175-177 Cleveland Street and 1-5
Woodburn Street, Redfern

FINAL RESPONSE
TO SUBMISSIONS

State Significant Development 15_7064

Part 5 and Part 6 storey mixed use development with two
retail tenancies, hotel accommodation with 76 rooms and
a residential apartment building containing 19 apartments
(SSD 15_7064)

REV E
E-12. REDUCTION IN SHADOW ON NEIGHBOURING BUILDINGS
REV B
B-13. SHADOW IMPACT OF PROPOSED DEVELOPMENT, COMPLYING HEIGHT AND NEIGHBOUR

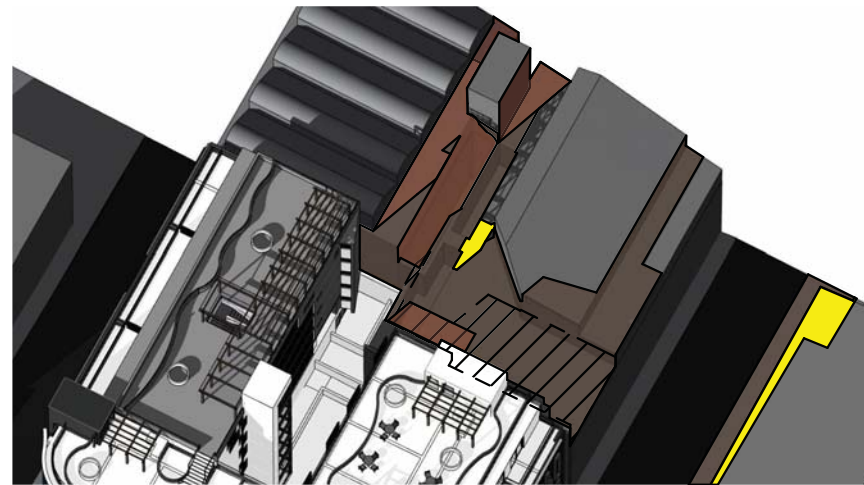
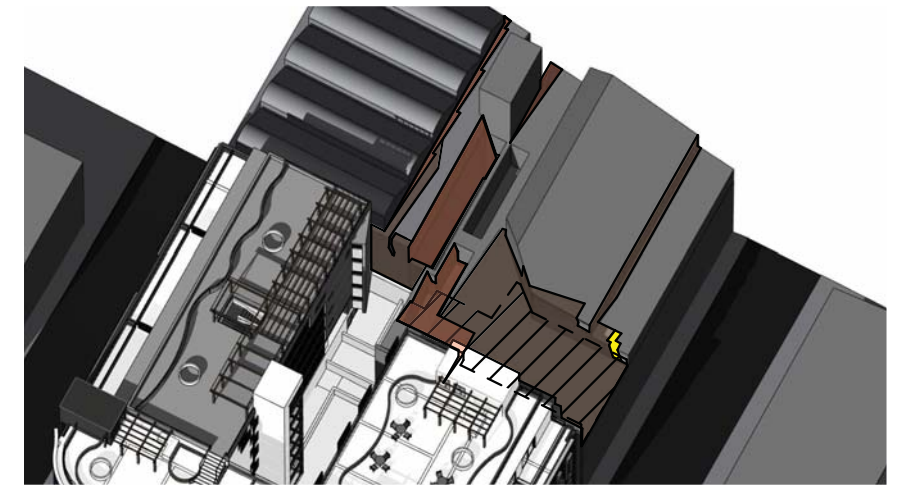
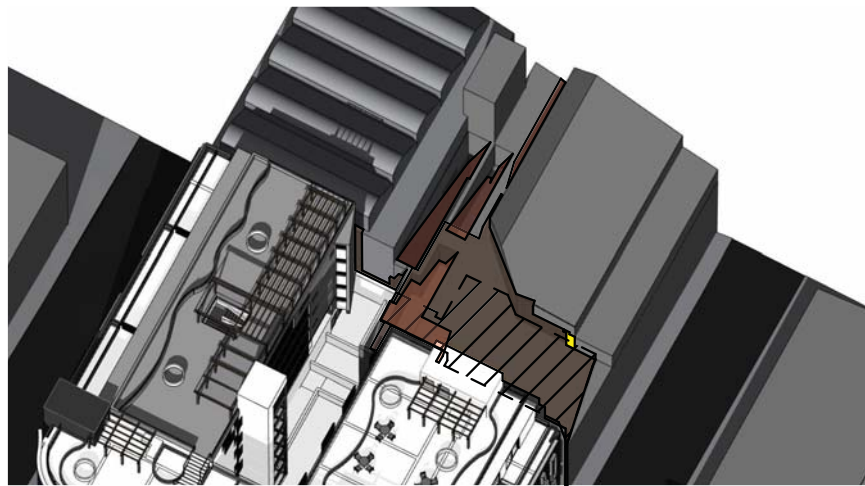
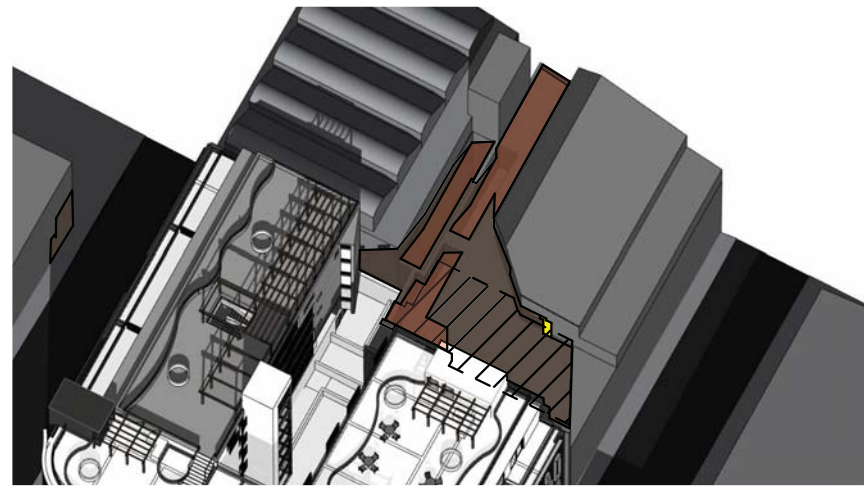
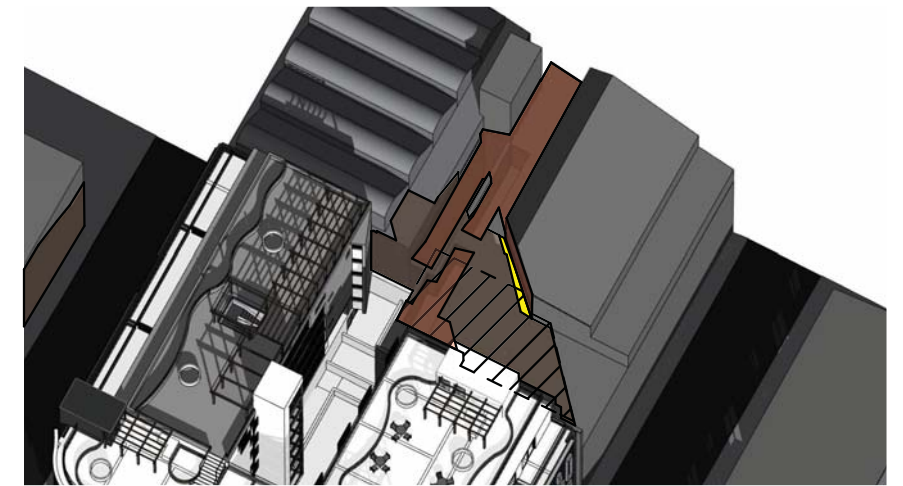
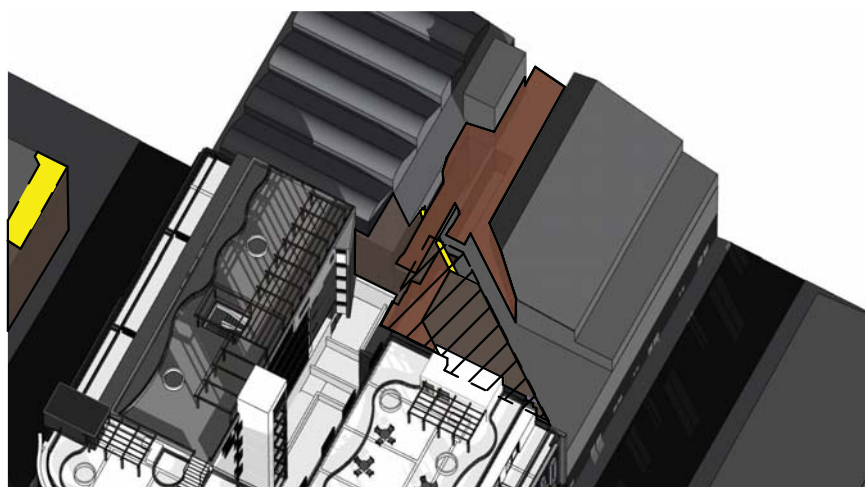
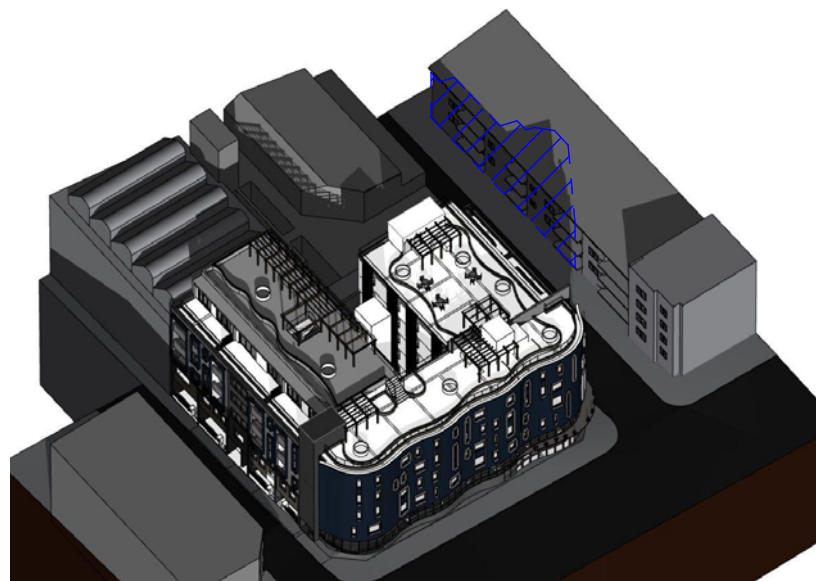
Issue	Response
Built Form and Urban Design	
<p>The proposed bulk and scale of the development is substantially greater than would be expected in the locality, particularly in the context of the surrounding development and the five storey maximum height control in State Environmental Planning Policy (Major Development) 2005 (Major Development SEPP). Further justification and detailed analysis is required to demonstrate the impacts of the proposal including:</p> <ul style="list-style-type: none"> • a comparative analysis of the overshadowing impacts of a complying development and the proposal (in both plan and elevation format), on neighbouring properties, particularly 165-173 Cleveland Street; and • a comparative visual analysis (including photomontages) of a complying development and the proposal to pedestrians at street level along Cleveland, Woodburn and Eveleigh Street. <p>Should the additional analysis provided indicate additional impacts over and above that of a complying scheme, these proposed exceedances should be reviewed and reconsidered.</p>	<p>The proposal has been substantially amended with the loft level facing Woodburn Street removed and the sixth floors facing Woodburn and Eveleigh Streets substantially setback so that the proposal now appears as a 5 storey development from the surrounding public domain.</p> <p>A comparative analysis of the overshadowing impacts of a complying development and the amended proposal accompanies this response in relation to the southern adjacent property in 6-8 Eveleigh Street as well as 165-173 Cleveland Street to the west across Eveleigh Street.</p> <p>6-8 Eveleigh Street</p> <p>The analysis illustrates that there is no difference in overshadowing to the principle usable area of the Level 3 common courtyard on the southern adjacent site between a complying scheme and the amended proposal. Whilst there is some additional overshadowing, this is predominantly to a walkway which leads to the principle usable area of the common open space. In addition, the principle usable area of common open space begins to enjoy sunlight from 1pm on 21 June and by 3pm approximately 50% of the area is in sunlight (this sunlight does not change between a complying height and the proposed height). Therefore, the proposed increase in shadow is not considered be significant and does not warrant any reduction to the height of the building.</p> <p>165-173 Cleveland</p> <p>The analysis illustrates that there is minimal difference in shadow between a complying height (i.e. the previously approved scheme) and the proposed height to the eastern facade of 165-173 Cleveland Street. In both circumstances, there is no shadow to this facade shortly after 10am.</p>

Issue	Response
	<p>The development at 165-173 Cleveland Street enjoys a high level of solar access from late morning and through into the late afternoon due to its eastern, northern and western aspect (the Urbanest development does not overshadow the western facade in the afternoon) and so it is likely that well over 70% of the apartments in 165-173 Cleveland Street will continue to enjoy more than 2 hours solar access at the winter solstice.</p> <p>The top of the proposed Woodburn Street apartment building has been substantially reconfigured with the removal of the loft level. The amended architectural package includes a comparison between the originally proposed Woodburn Street elevation, the first amendment and the final amended elevation which illustrates that the additional structure above 5 storeys is no longer visible from the public domain such that the proposal now visually appears as a compliant number of storeys. The minor additional level therefore does not result in any discernible impact which would require it to be removed. The amended proposal is considered to be generally consistent with the scale of development anticipated by the planning controls which apply to the site.</p> <p>The amended architectural package also includes a photomontage comparison between the approved/compliant development and the proposal which demonstrates that the final amended proposal actually presents a reduced scale.</p>
